From: Paul Cann
Sent: 04 August 2011 17:41
To: Planning.Responses
Cc: Brian Holland
Subject: FW: Planning Consultation on: LU/156/11/DOC at Land South of Hearnfield Road

Engineers comments:-

Description of Works: Application for approval of details reserved by conditions 4, 5, 6, 9, 11, 13, and 16 following a grant of planning permission LU/63/10

HIGHWAY SOAKAWAY CO-ORDINATE CONTROL		
SA No.	EASTINGS	NORTHINGS
SA1	1022.853	969.771
SA1	1027.853	969.771
SA2	1024.184	943.849
SA2	1029.176	943.655
SA2	1034.168	943.282

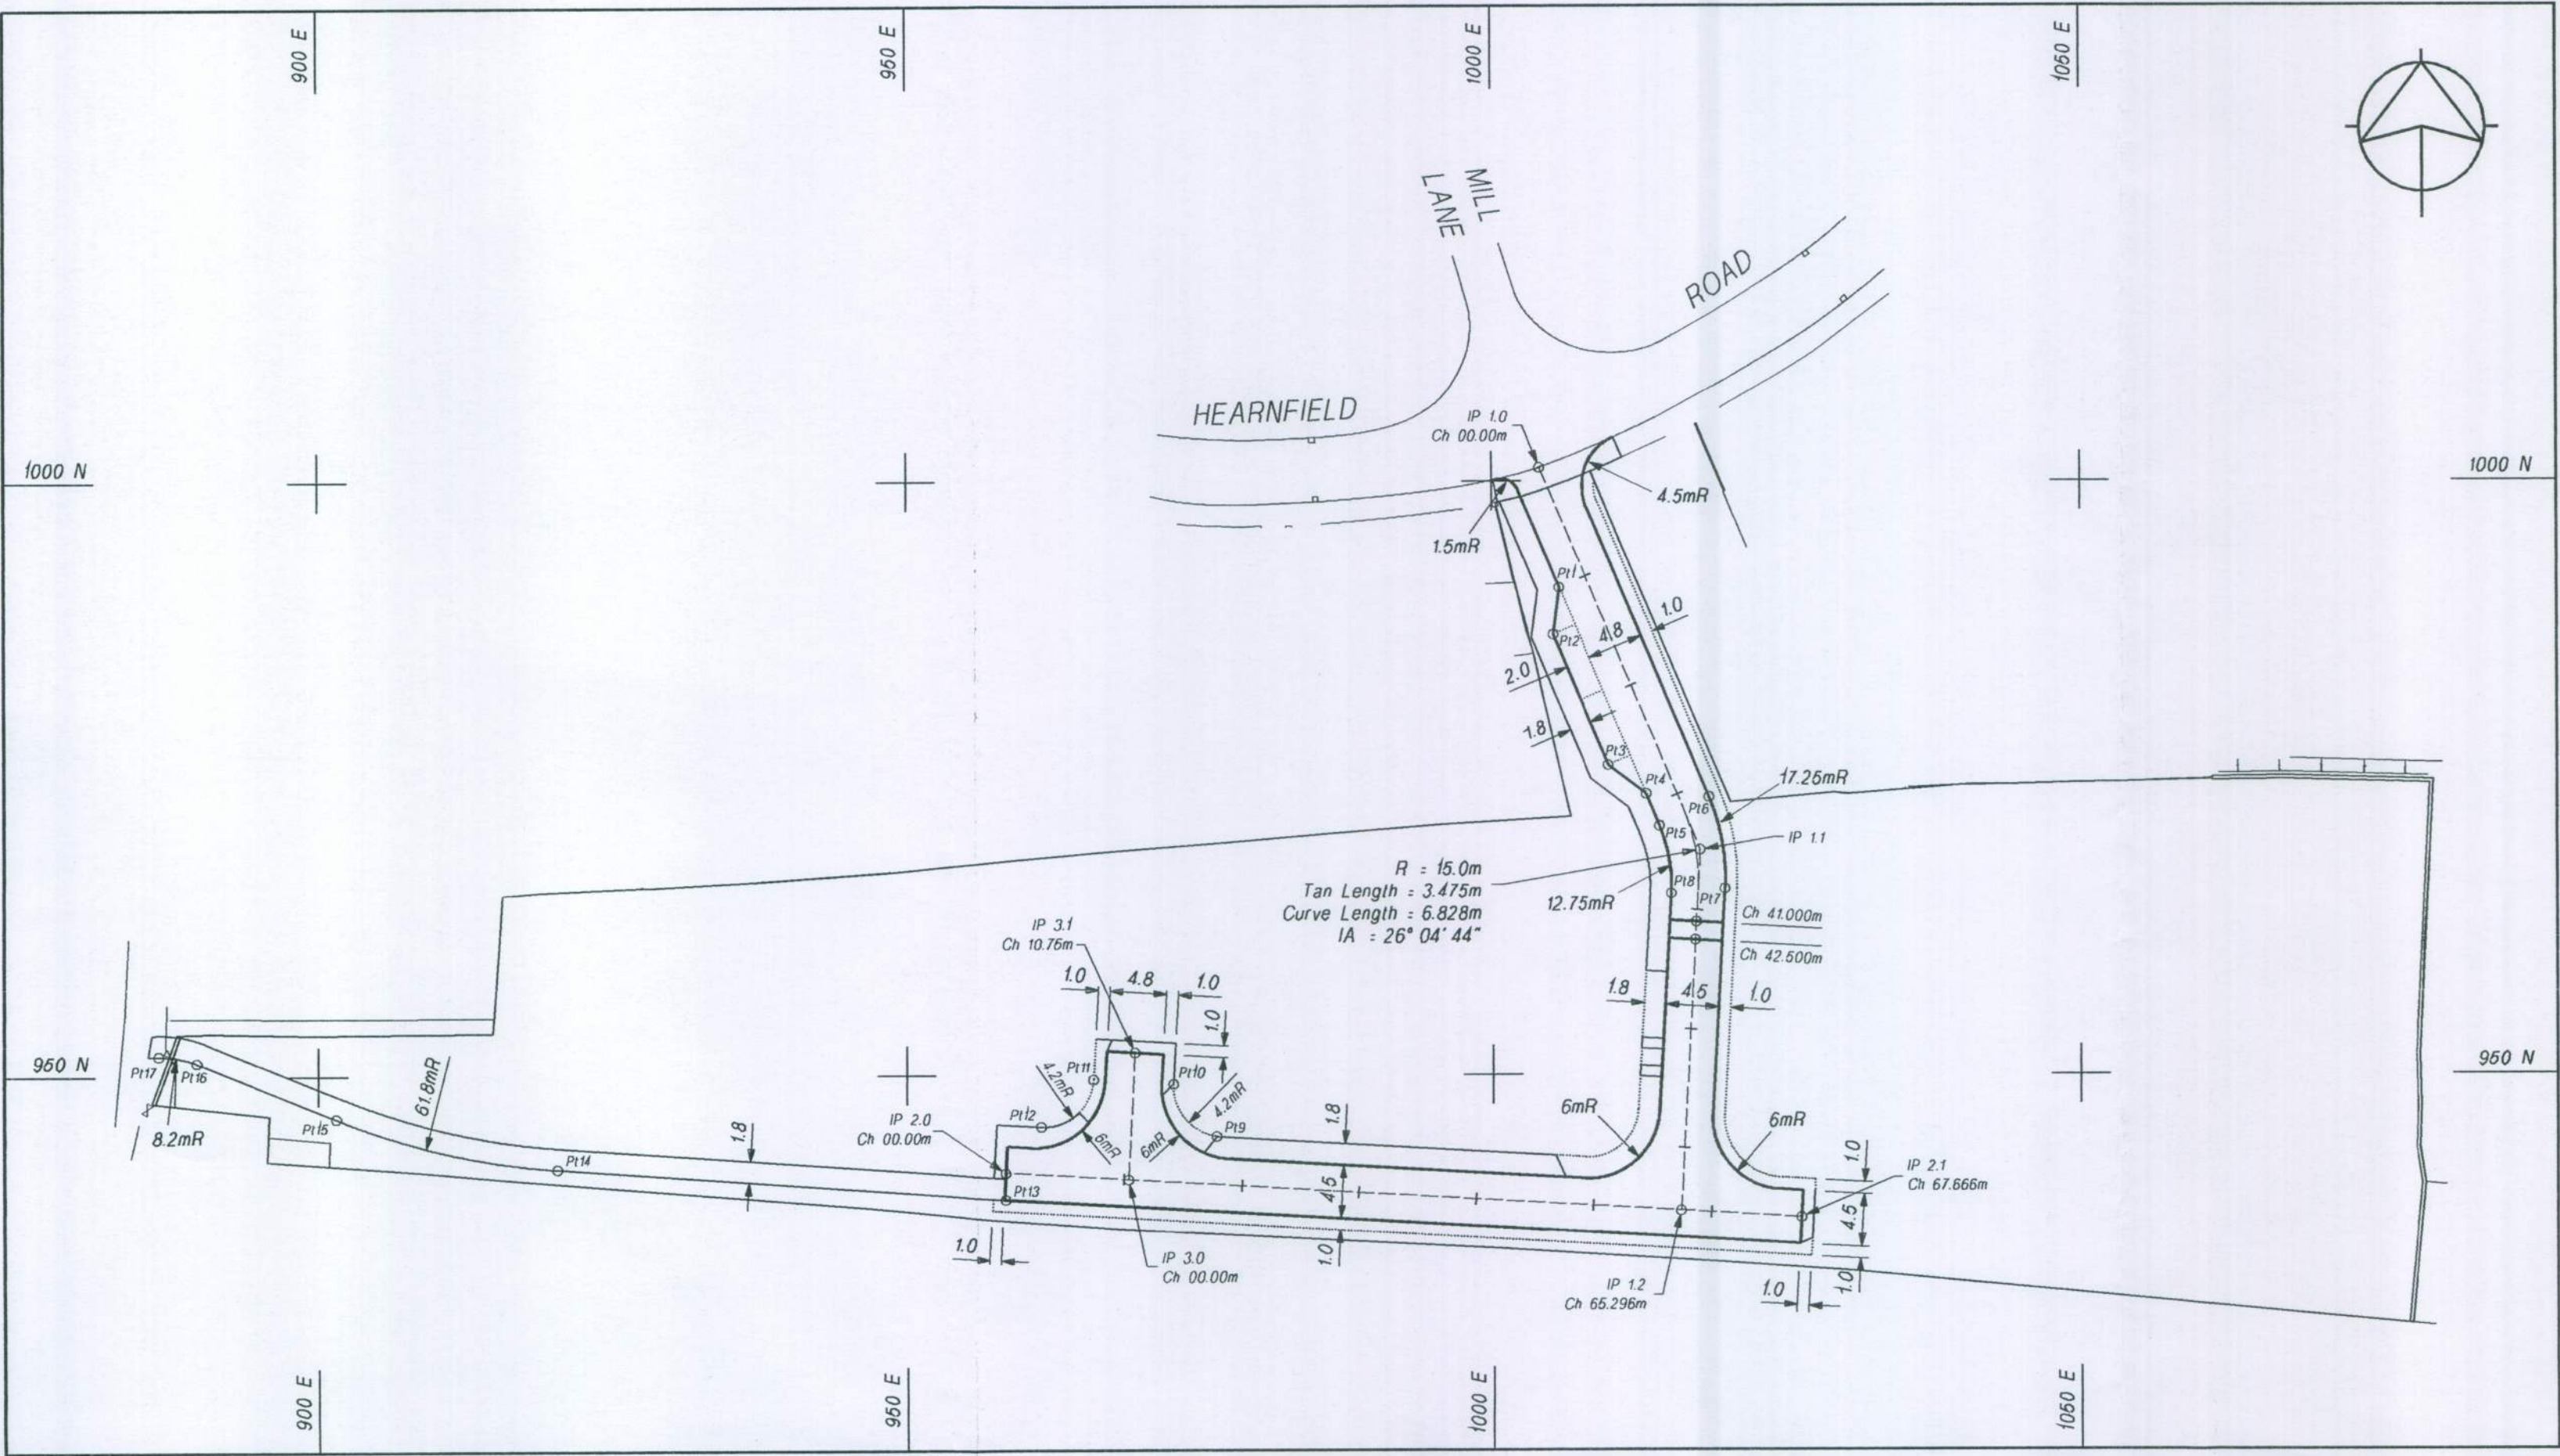
4. Highway soakaways SA1 and SA2 are to be adopted by West Sussex County Council. Confirmation of their technical approval to the design will also be required.

5. The base levels used in the 1 in 100 year calculations submitted do not correspond to those shown on Drg. 210389/14.
6. Full calculations need to be submitted for all other soakaway structures ie. those serving roofs and private drives. Percolation tests are required at the location of these structures and must be carried out in the winter period. Please note that the base of the soakaways need to extend into the better permeable strata ie. chalk. This was discussed in items 6.5 of the report by Robert Clark Associates in Nov 2009.

SECTION - PRIVATE DOMESTIC SOAKAWAY

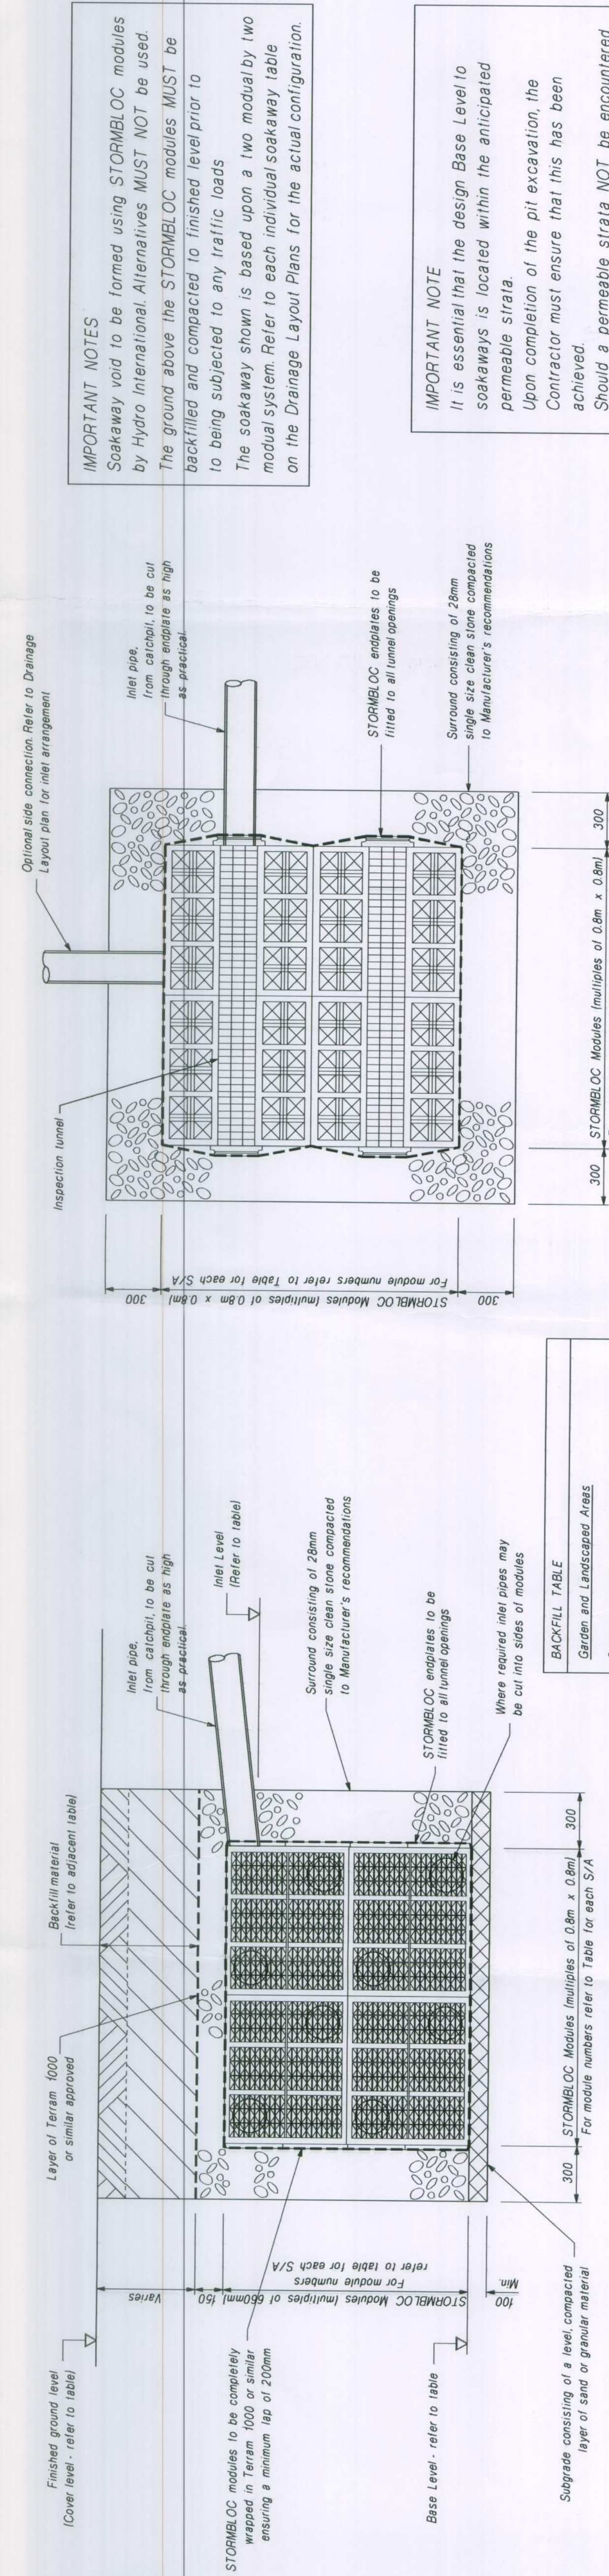
7. Calculations are required to prove that the soakaways will half empty within a 24 hour period.
